CITY OF PORTLAND, MAINE

Project Name: 3 Pleasant Avenue Church Redevelopment
Address: 3, 15, and 16 Pleasant Avenue
Applicant: Hardypond Development Company
Planner: Nell Donaldson

Project ID: 2015-102
CBLs: 130-H-13, I-12, and I-14

Pleasant Avenue Church Redevelopment
3, 15, and 16 Pleasant Avenue
Level III Site Plan and Subdivision Review
2015-102
Peninsula Property Development

1 SOUTH (PLEASANT AVENUE) ELEVATION  
1/4" = 1'-0"

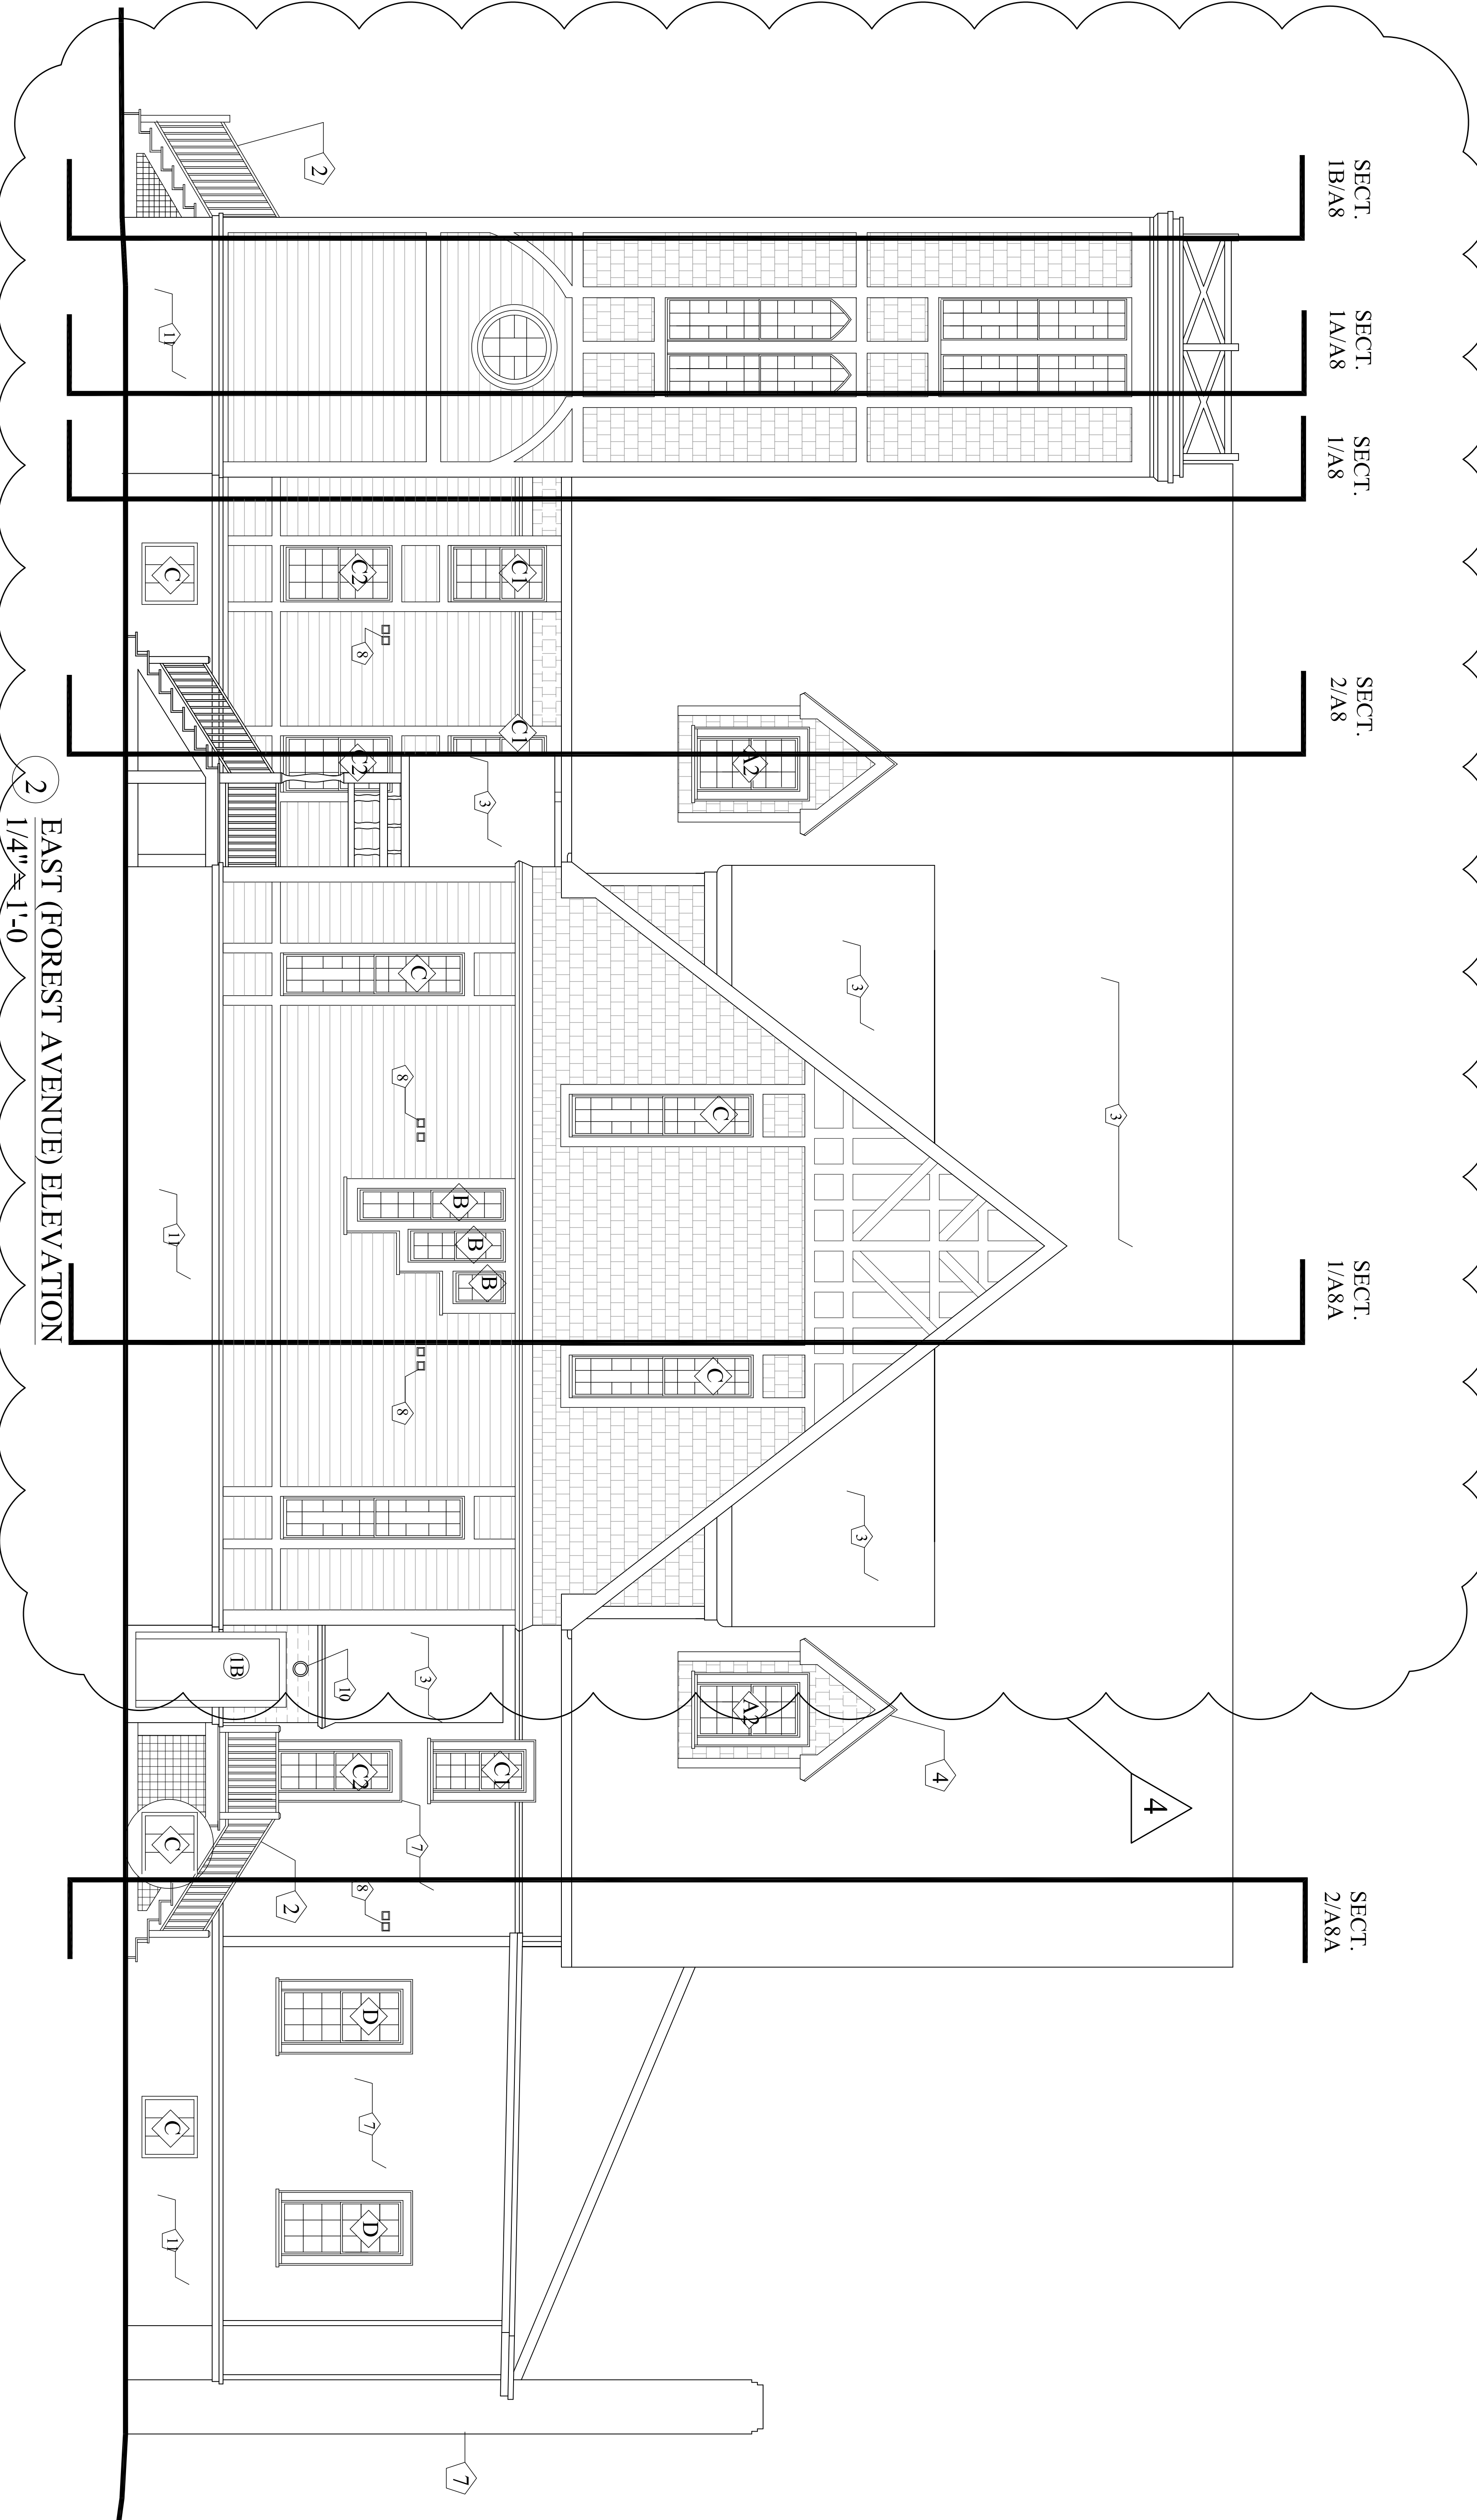
historic character. Based on the multi-family design standards, the city's urban designer has requested that the applicant:

- Review the elevations, particularly with respect to the north side, to ensure that the drawings accurately depict the existing roof design and window pattern;
- Align proposed windows on the second and third floors on the north side with existing first floor windows; and
- Confirm that proposed dormers match the existing roof pitch.

3. The applicant shall provide revised elevations addressing the multi-family design standards for review and approval by the Planning Authority.

1 NORTH ELEVATION
1/4" = 1'-0"

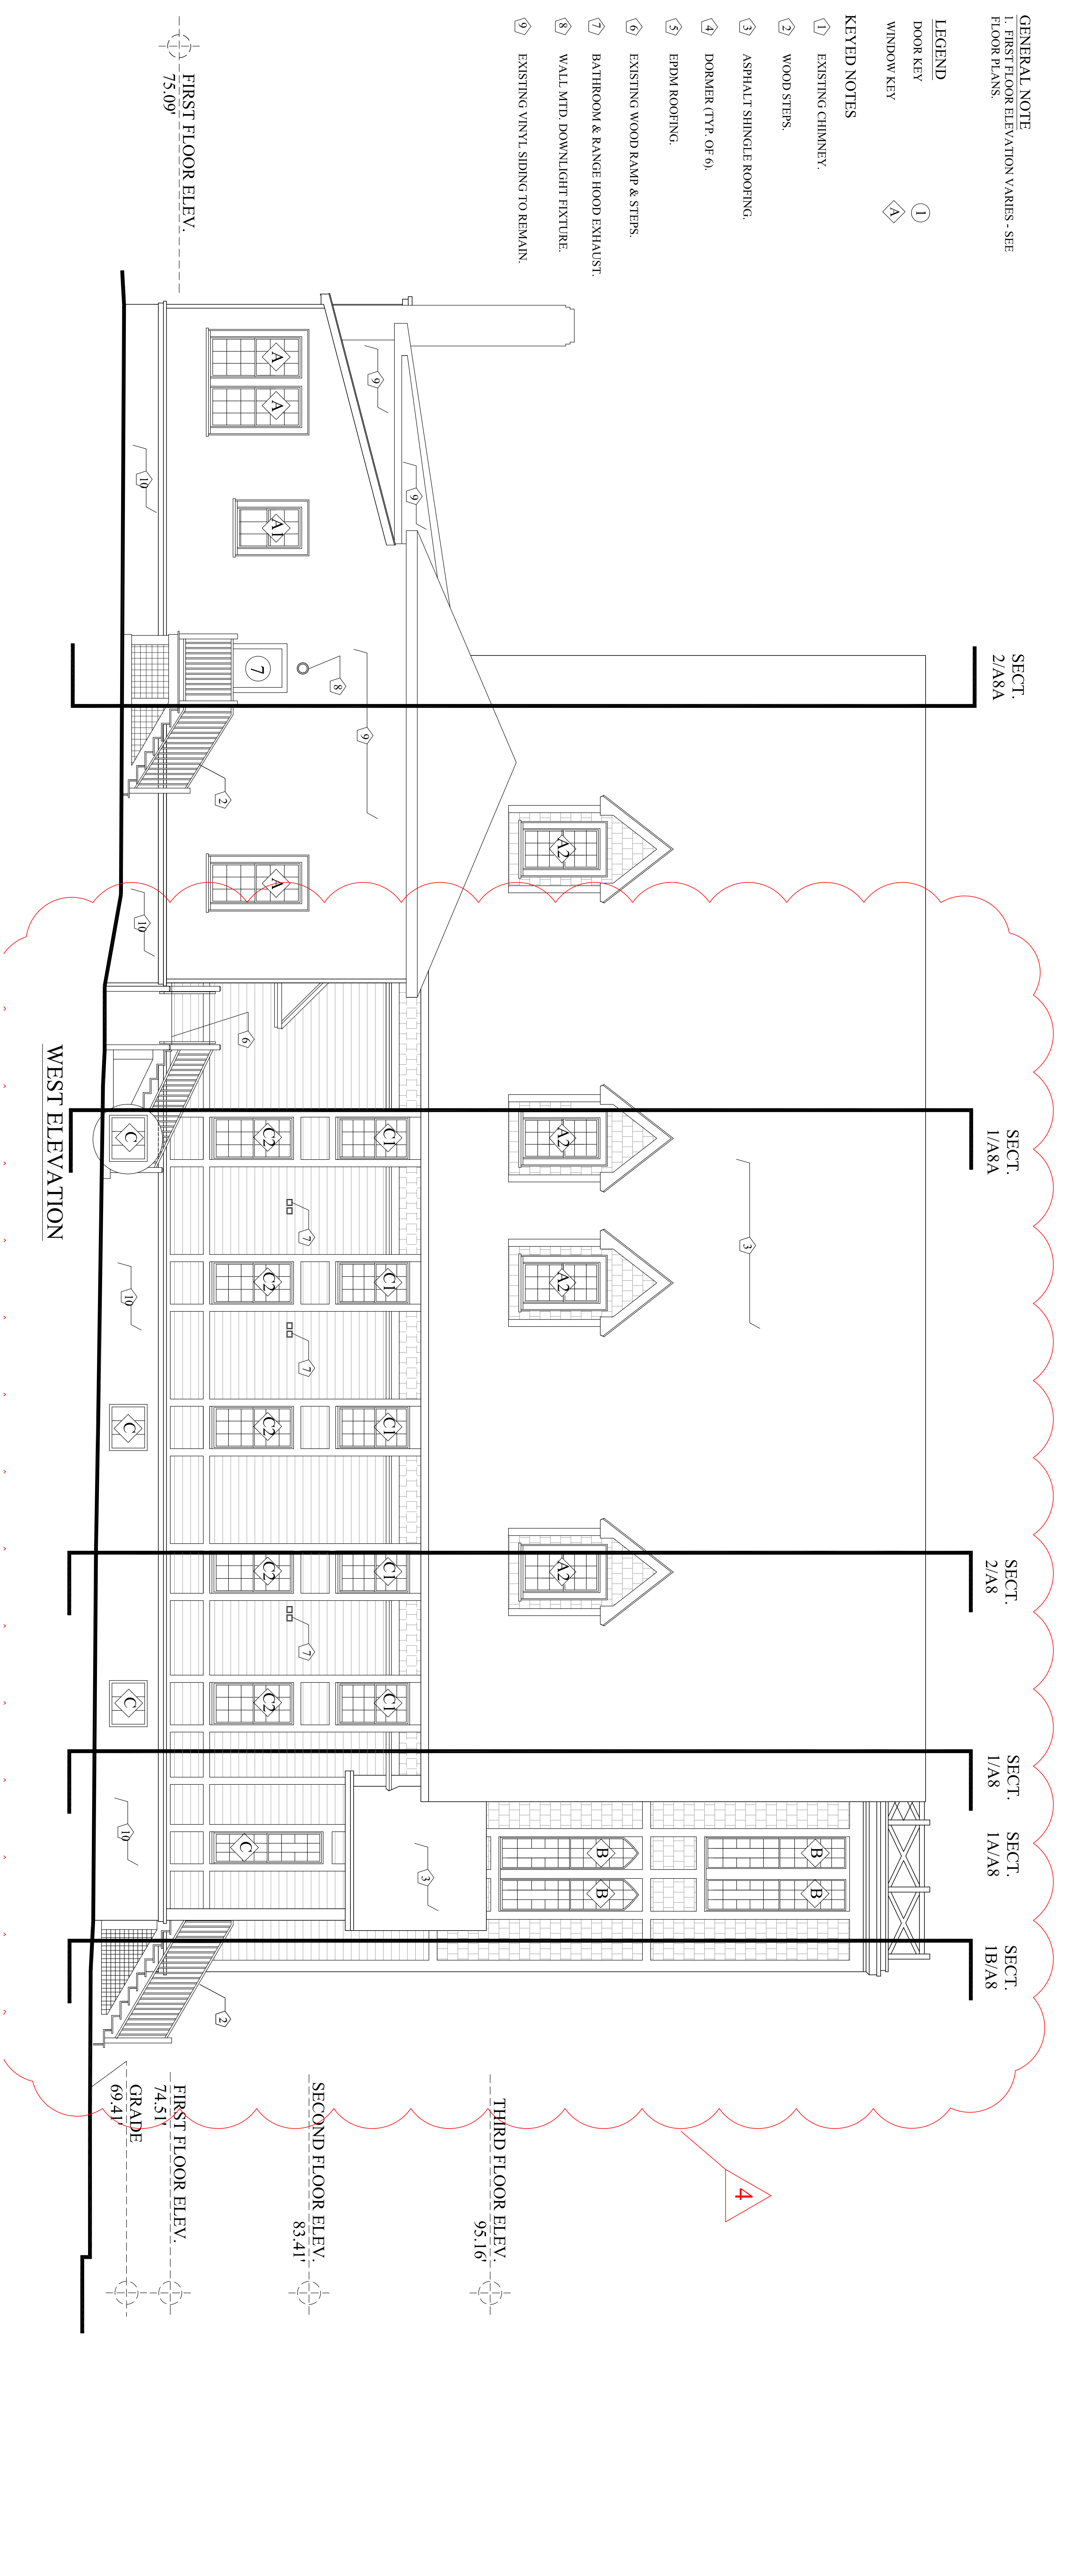
At the time of final plan review, no additional drawings had been provided. The resolution of the design comments has been included as a condition of approval.

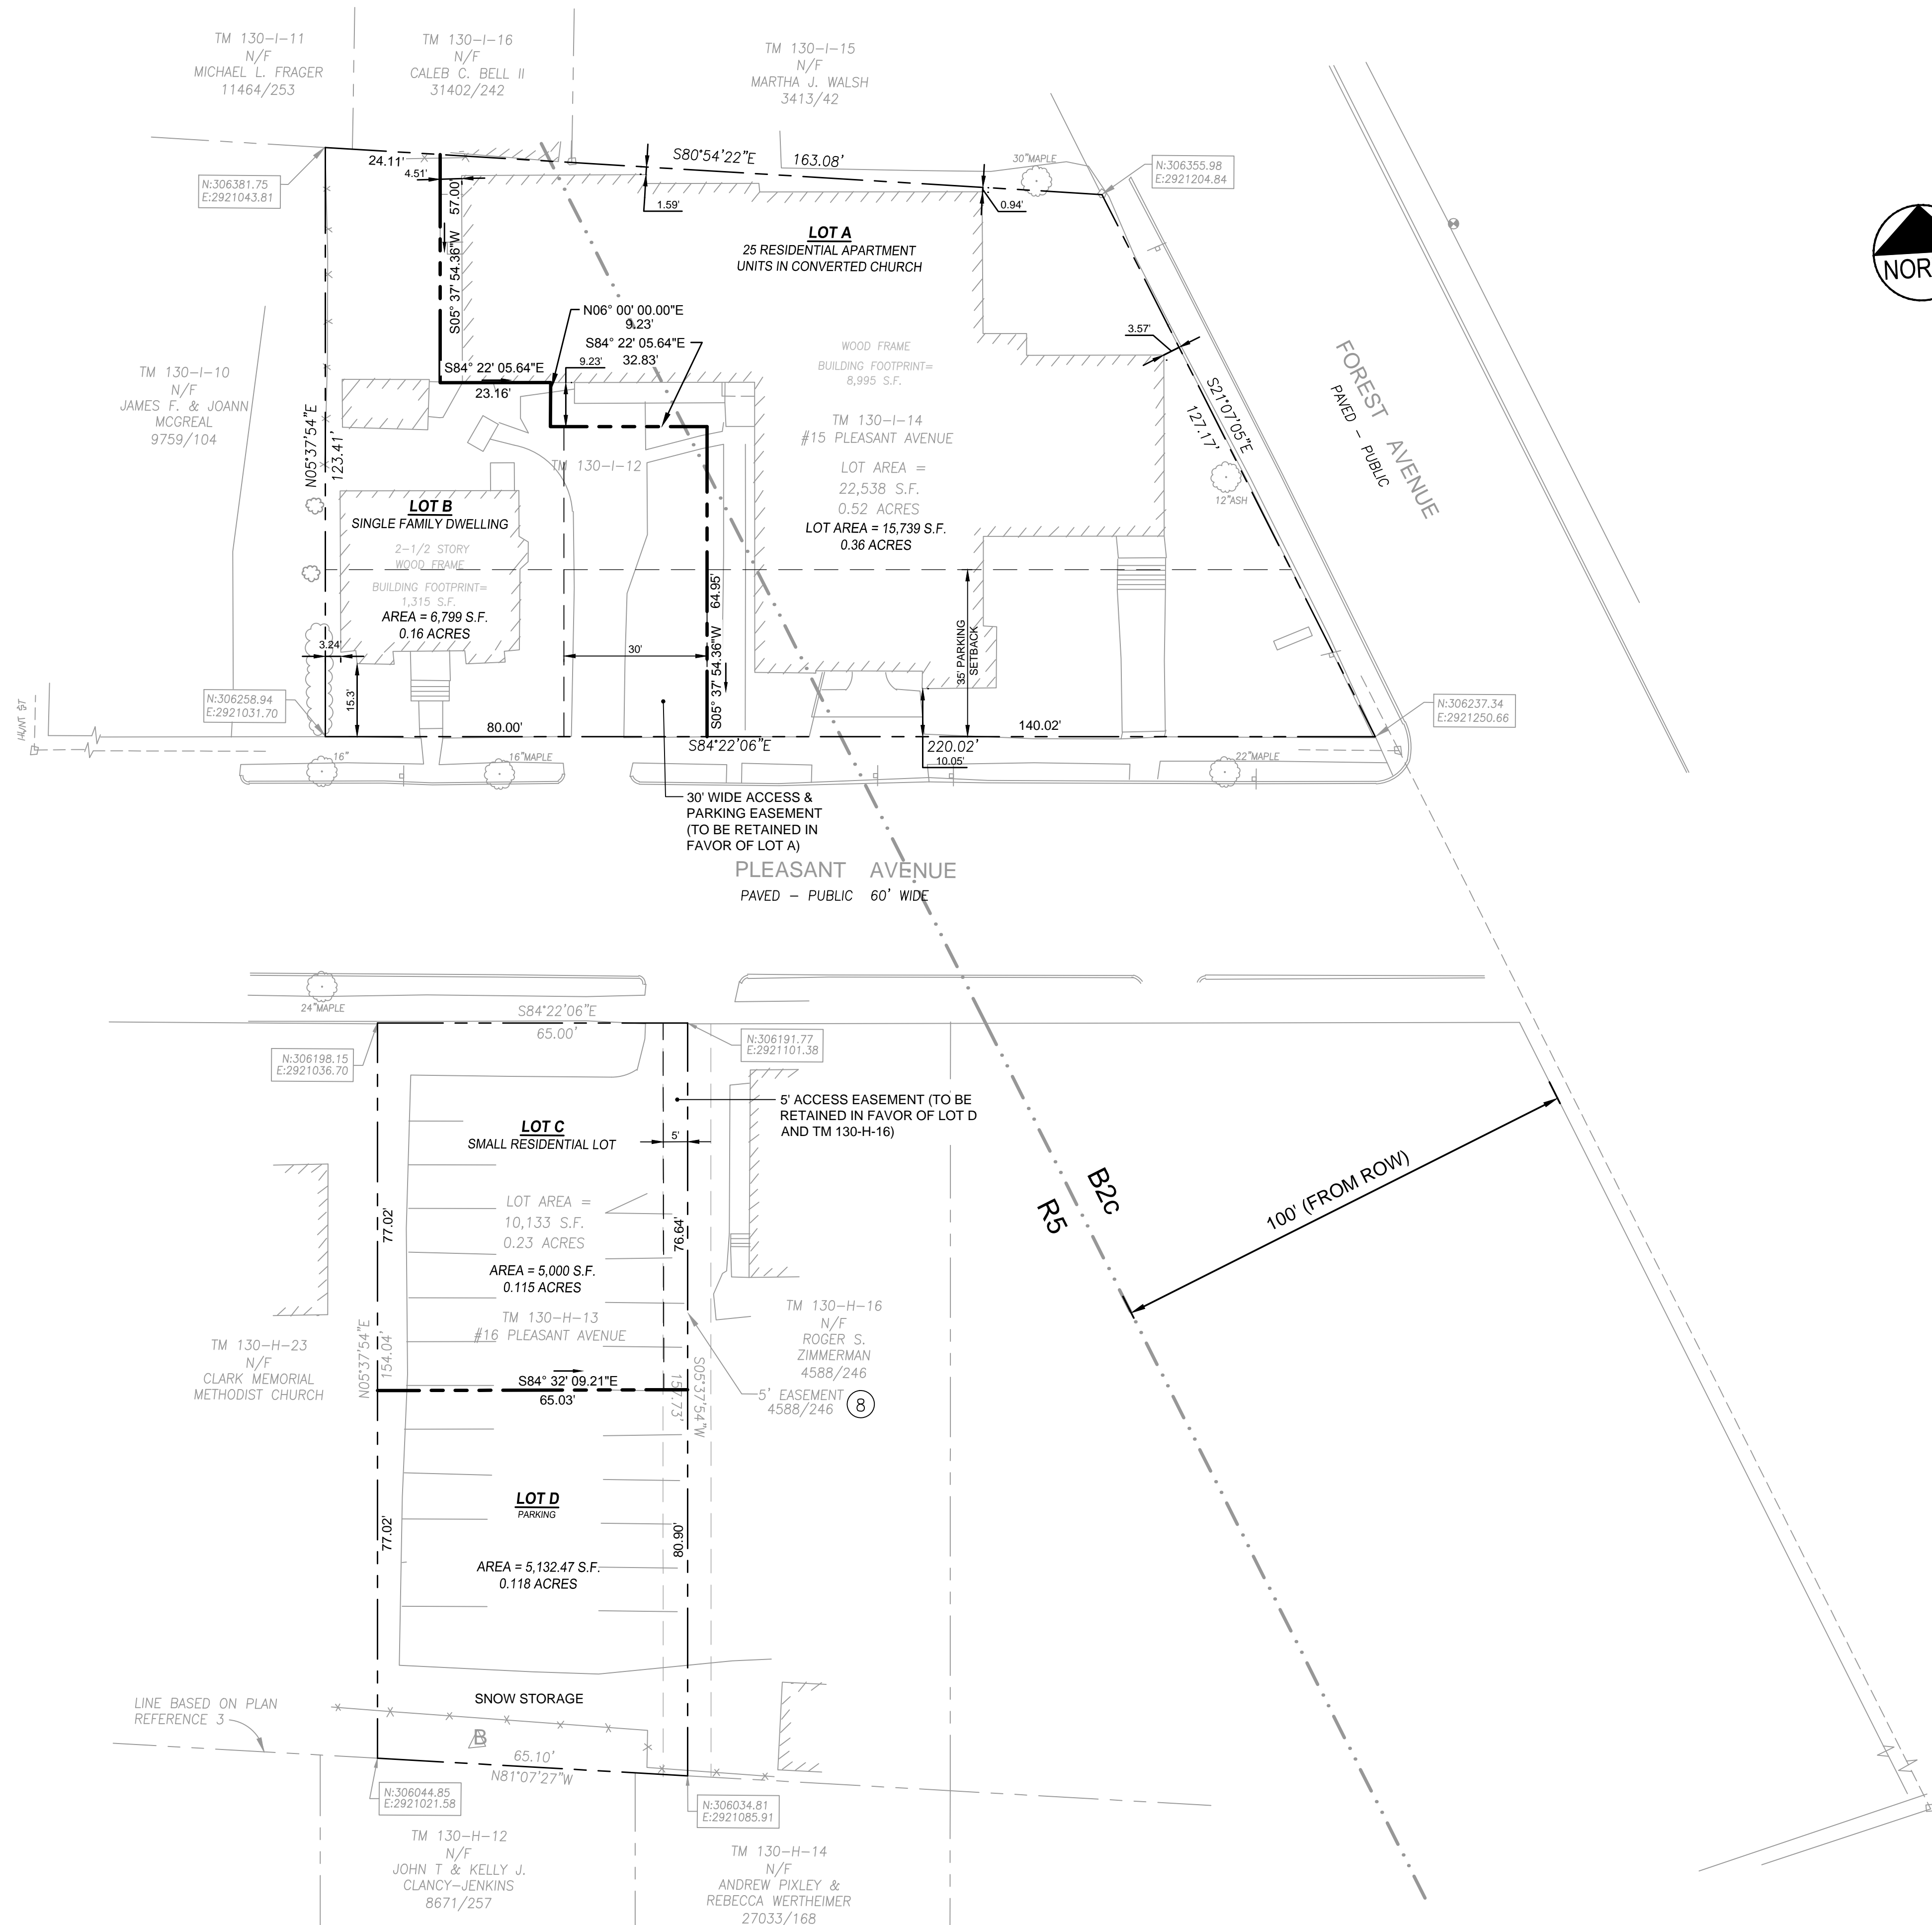
Staff has reviewed the subdivision plat. The city's surveyor has indicated his approval (*Attachment 5*). The plat remains to be fully reviewed by Corporation Counsel, and elements relating to easements, a unit breakdown, and any conditions of approval remain to be added. A final subdivision plat meeting the requirements of *Section 14-496(b)* has been included as a condition of approval.

1. The applicant shall finalize the subdivision plat to meet the requirements of *Section 14-496* for review and approval by Corporation Counsel, the Department of Public Services, and the Planning Authority; and
